**KIRKLEES METROPOLITAN COUNCIL  
INVESTMENT & REGENERATION SERVICE**

**DELEGATED DECISION TO DETERMINE PLANNING APPLICATIONS**

Reference No:	<b>2023/62/92119/W</b>
Site Address:	106, Lamb Hall Road, Longwood, Huddersfield, HD3 3TJ
Description:	Erection of replacement front steps and associated alterations
Recommending Officer:	Luke Walstow

## **OFFICER REPORT**

Project	REPLACEMENT STEPS : 106 LAMB HALL ROAD	
Client	MR CHRISTOPHER MARSDEN	
Drawing	BLOCK PLAN SHOWING FRONTAGE	
Scale	1 : 50	Date 27 10 23
Dwg No	2023 737 04 A	Rev

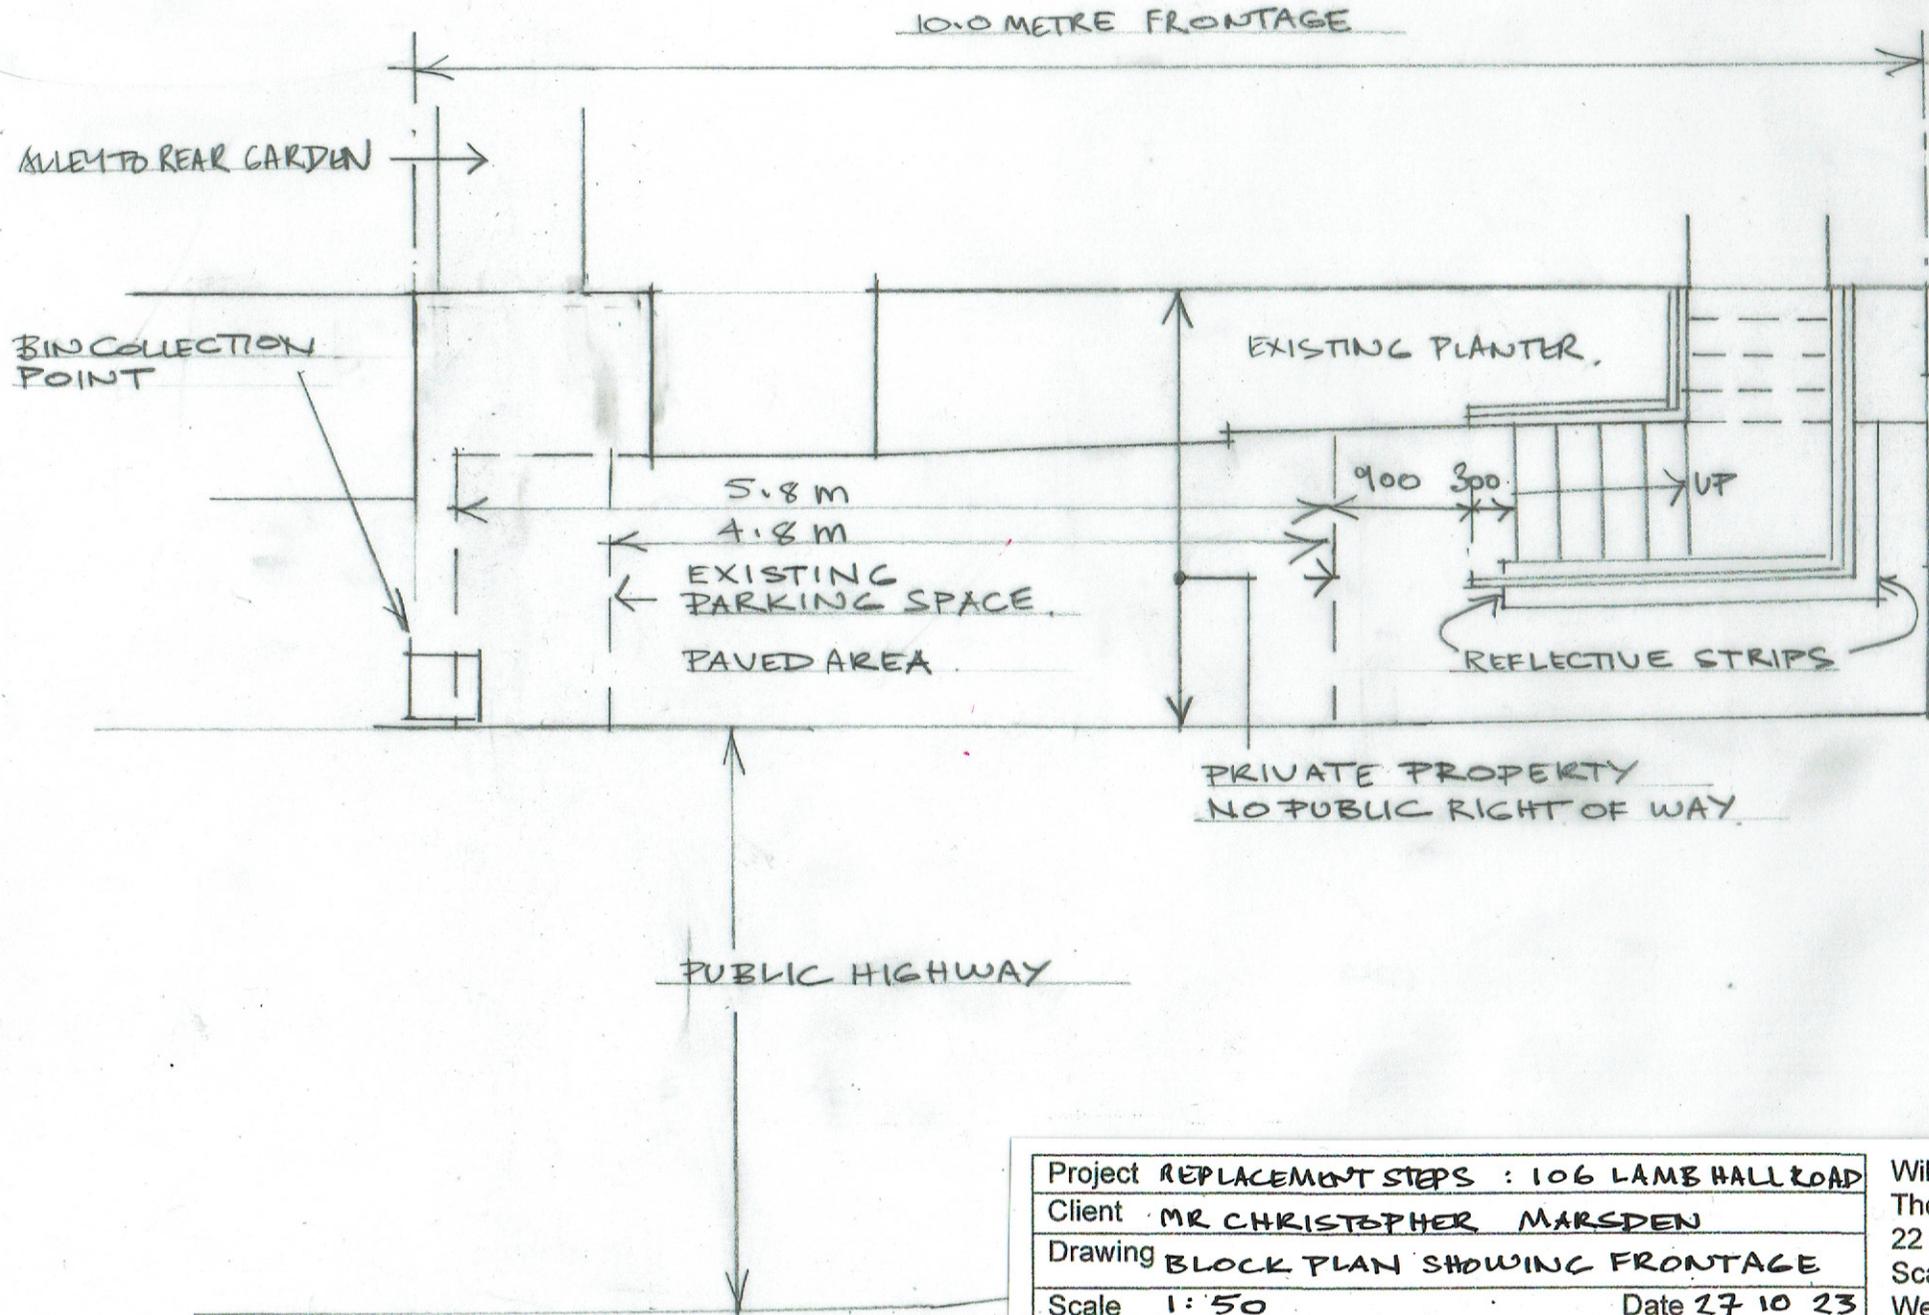
KC Highways – No objection given the footway is not adopted highway. Requested the applicant to show where bins would be stored, and reflective strips placed upon the steps to prevent highway accidents occurring.

Reflective strips have been added to the steps (within the submitted amended plans) in order to reduce the potential for the structure being struck by vehicles at the request of KC Highways. Amended plans have been submitted showing a car can park in front of the dwelling should the proposed steps be constructed. On the basis of the inclusion of a condition requiring the provision of the reflective strips to the structure KC Highways and planning officers have no objection to the proposal under highway specifications.

The applicant has specified where bin will be stored, which has been accepted by KC Waste Planning and KC Highways.

4. Two reflective strips shall be in place prior to the development being brought into use, in the locations detailed upon submitted drawing 202373704 RevA and retained thereafter.

Project REPLACEMENT STEPS : 106 LAMB HALL RD.	
Client MR CHRISTOPHER MARSDEN	
Drawing PLANS, ELEVATION & SECTION AS PROPOSED	
Scale 1:50	Date 20 06 23
Dwg No 2023 737 03	Rev C

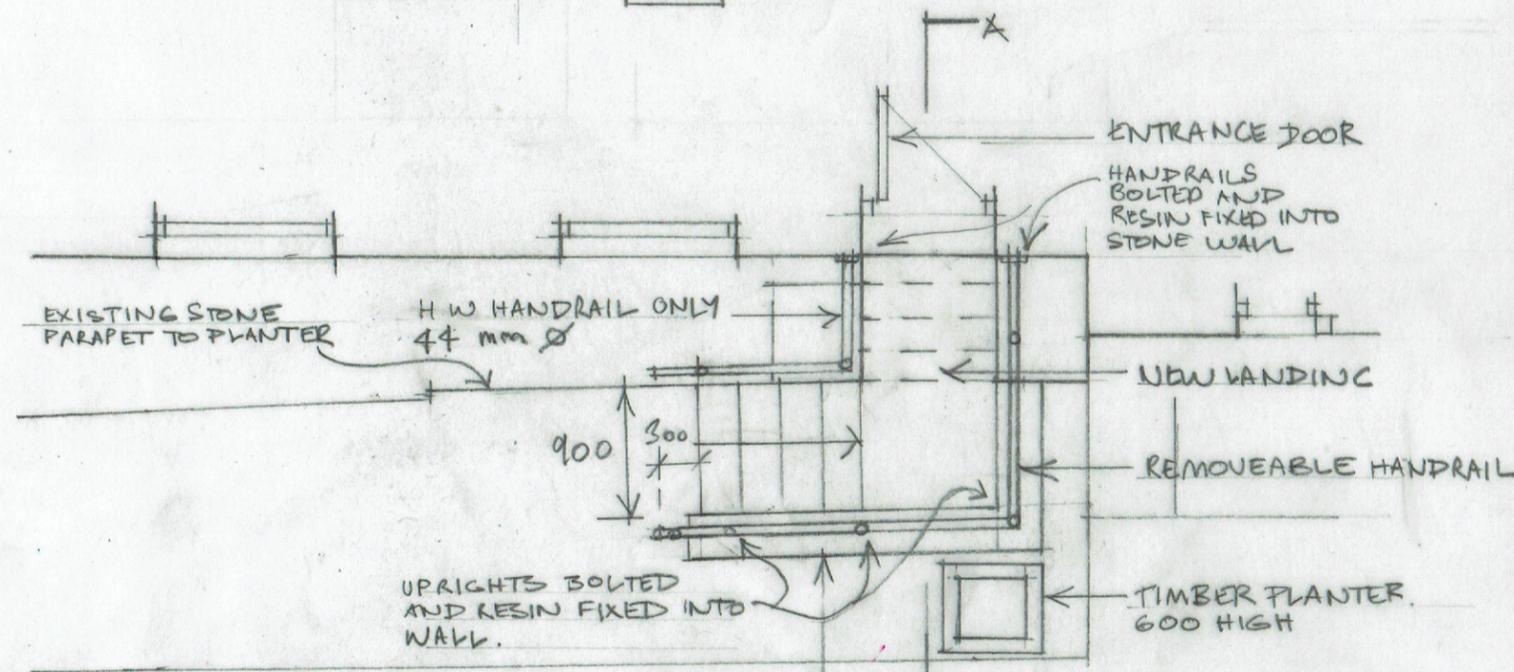
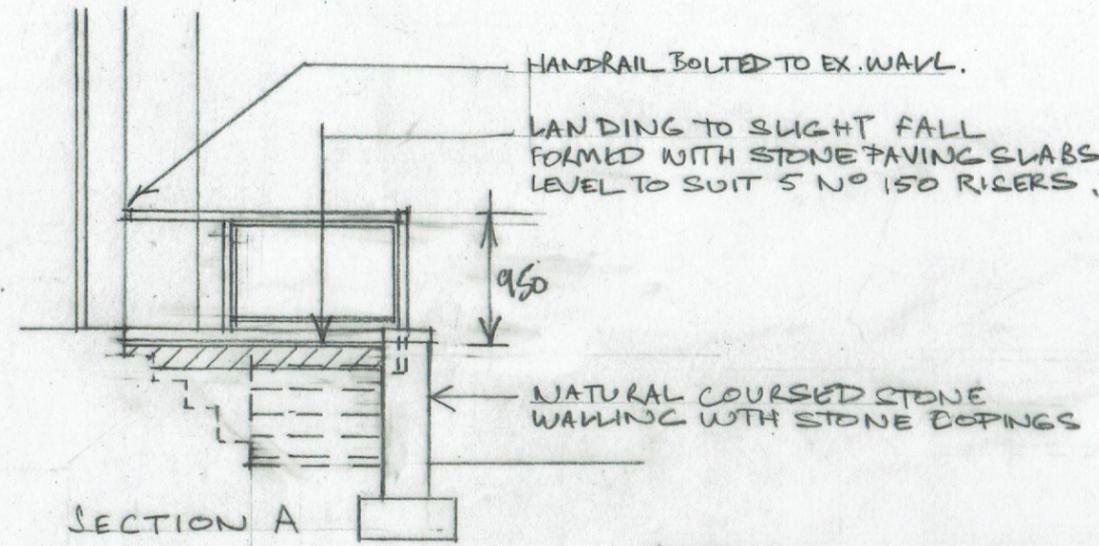
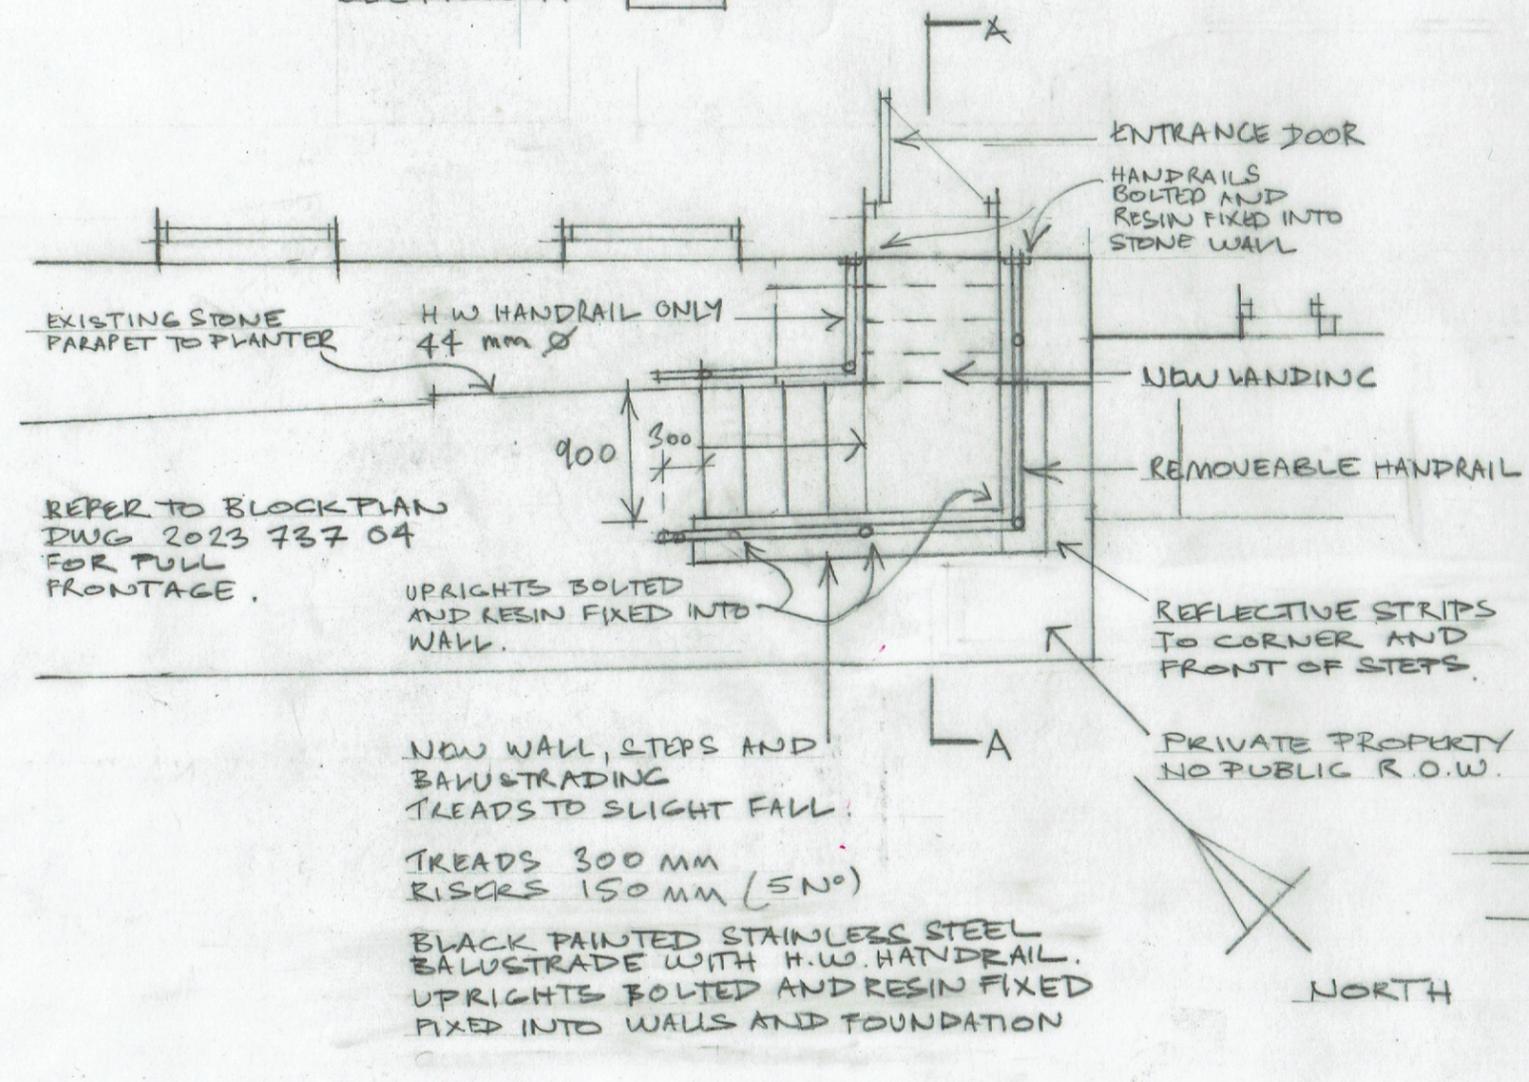
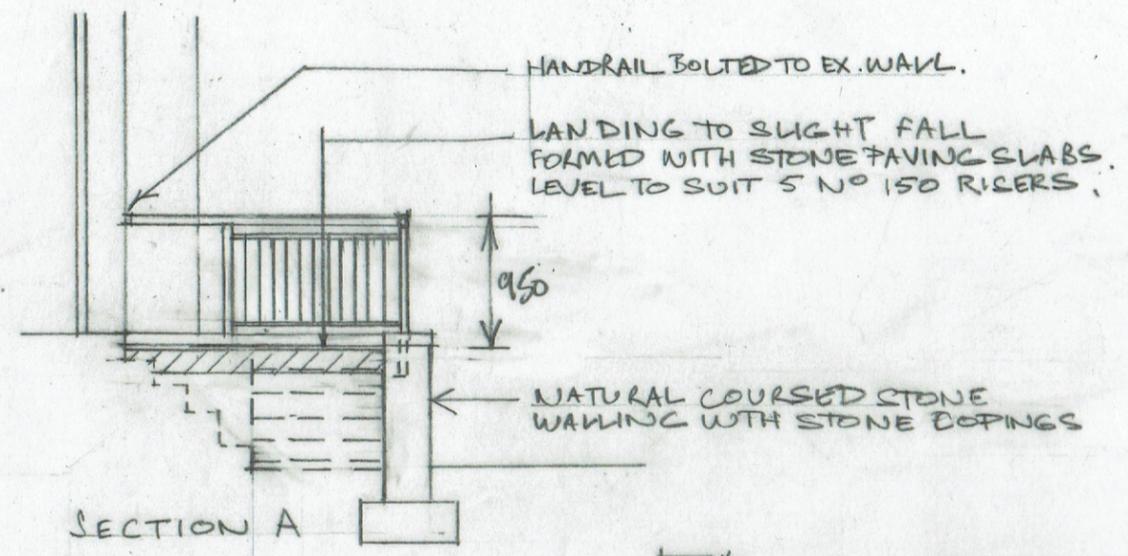
Amendments have been sought to change the glass balustrades submitted on submission to be black stainless steel metal railings. This was requested so that the development would not hinder the setting of the adjoined listed building. The agent was asked to confirm where bin storage would be given parking arrangements would slight change with the introduction of the steps. Reflective strips have also been requested in order to prevent oncoming traffic hitting the steps.

KC Conservation and Design – Internal consultations regarding the impact the proposal would have on the listed building adjoined to the host dwelling of the application site. Recommend the removal of the glass balustrade and recommended traditional black railing to be used.

The proposed steps would be constructed from natural coursed stone, which would match materials of the host dwelling and surrounding dwellings. The steps are small in footprint and mass and would be a subservient addition to the dwelling. The balustrades are to be stainless steel and black colour finish. This new proposed material is considered to be acceptable and would not detract value away from the adjoined listed building. It is considered the proposal would not cause harm to the listed building given the design and materials proposed and in this case there is not a requirement for public benefits to be in place to outweigh any identified harm.

3. The external materials of construction shall be natural coursed stone to match the host property with stone copings and steel railing balustrade of a black colour finish in accordance with the details set out within submitted drawing 202373703RevC and retained thereafter.
